Planning application no: 3/2013/0432

Proposal: Proposed renovation of the existing shop front to include replacement canopy.

Location: Dil-Raj Restaurant, 7 - 9 Parson Lane, Clitheroe BB7 2JP.

AS PROPOSED

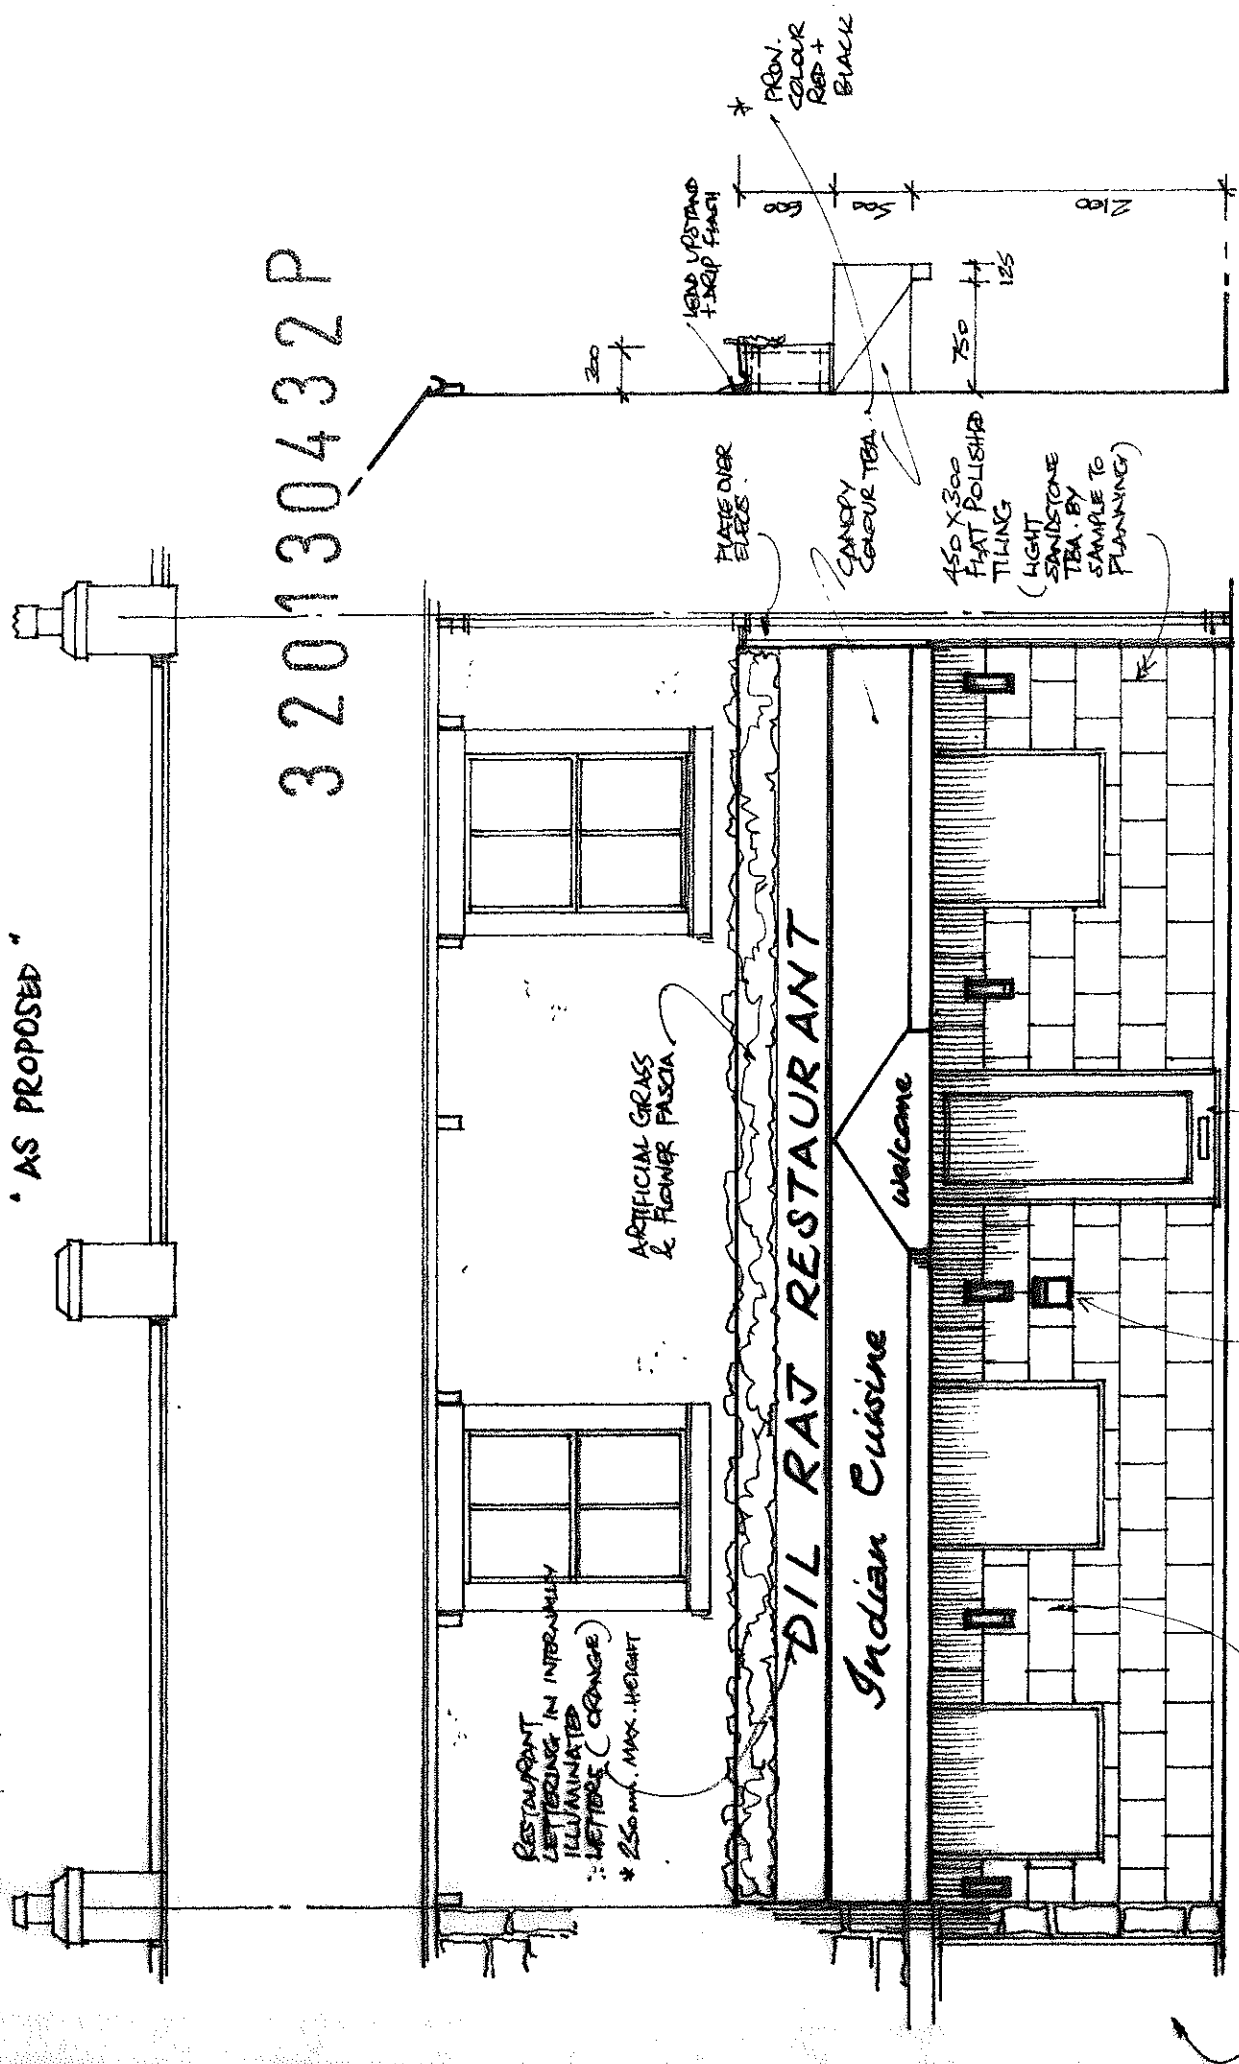
The minimum height above the footway surface should be 2.5m, and this canopy is less than 2.1m.

In addition the canopy extends 875mm over the highway and this may result in the need for a licence in terms of S177 of the Highways Act.
